Greater Dublin Drainage Project Addendum

Environmental Impact Assessment Report Addendum: Volume 2A Part A of 6

Chapter 4A Description of the Proposed Project

October 2023

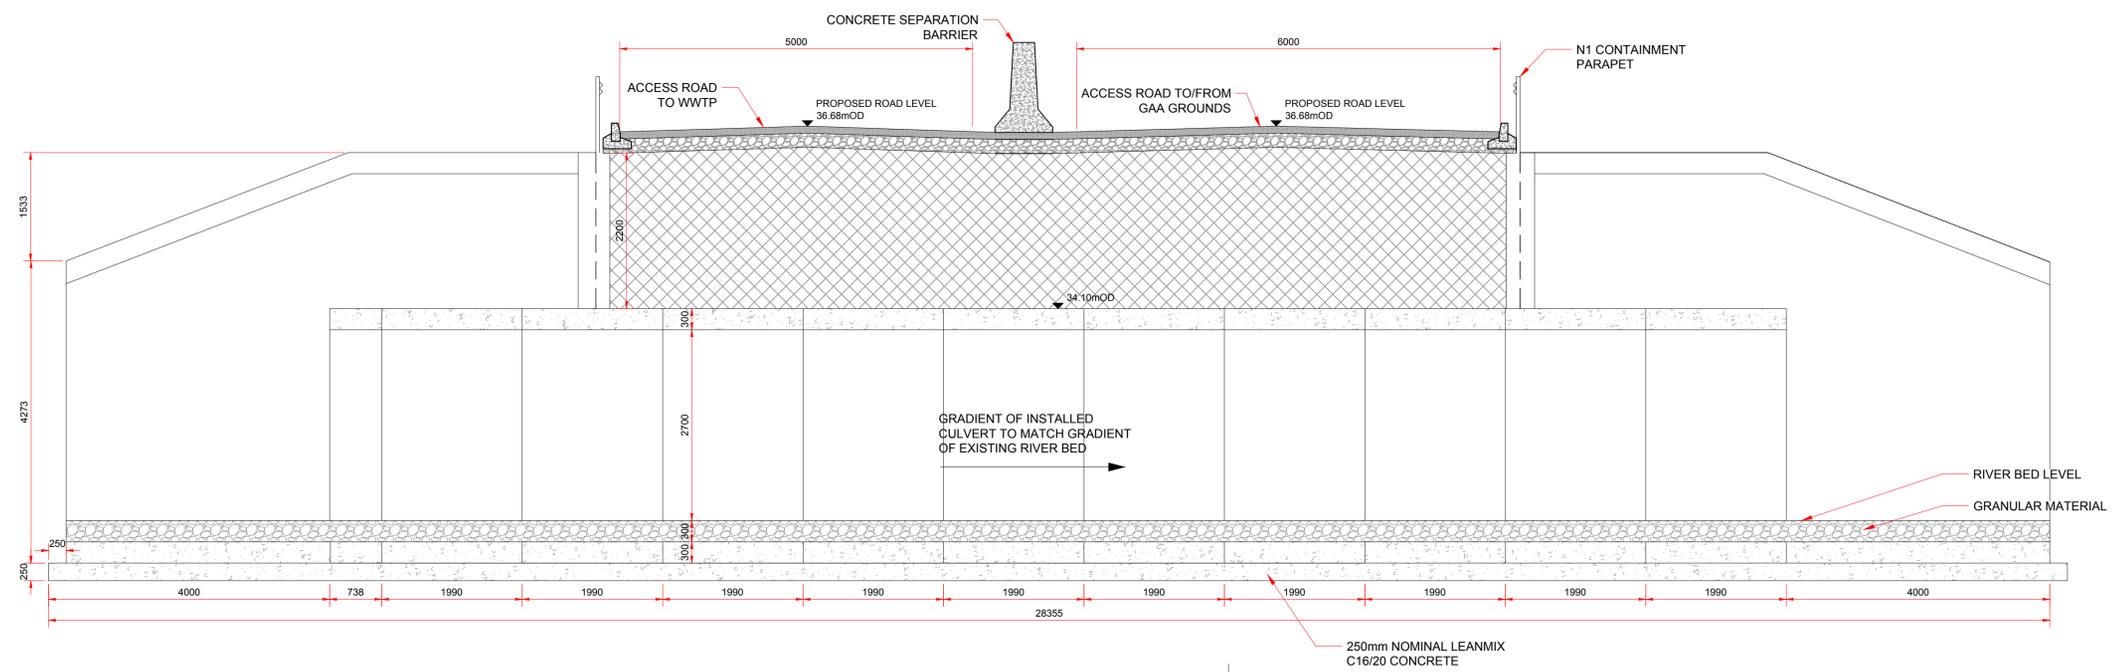
The culvert will be extended by 4m from the original 21m presented in the 2018 planning application to 25m, in order to meet the requirements of Condition 13(c). The proposed culvert extension remains within the planning boundary submitted in the 2018 planning application and is presented in Addendum Planning Drawing Numbers 32102902-2148 and 32102902-2149.

'the developer shall increase the width of the culvert at the crossing of the River Mayne as part of the Clonshaugh site entrance, to cater for the full width of the future north south link road.
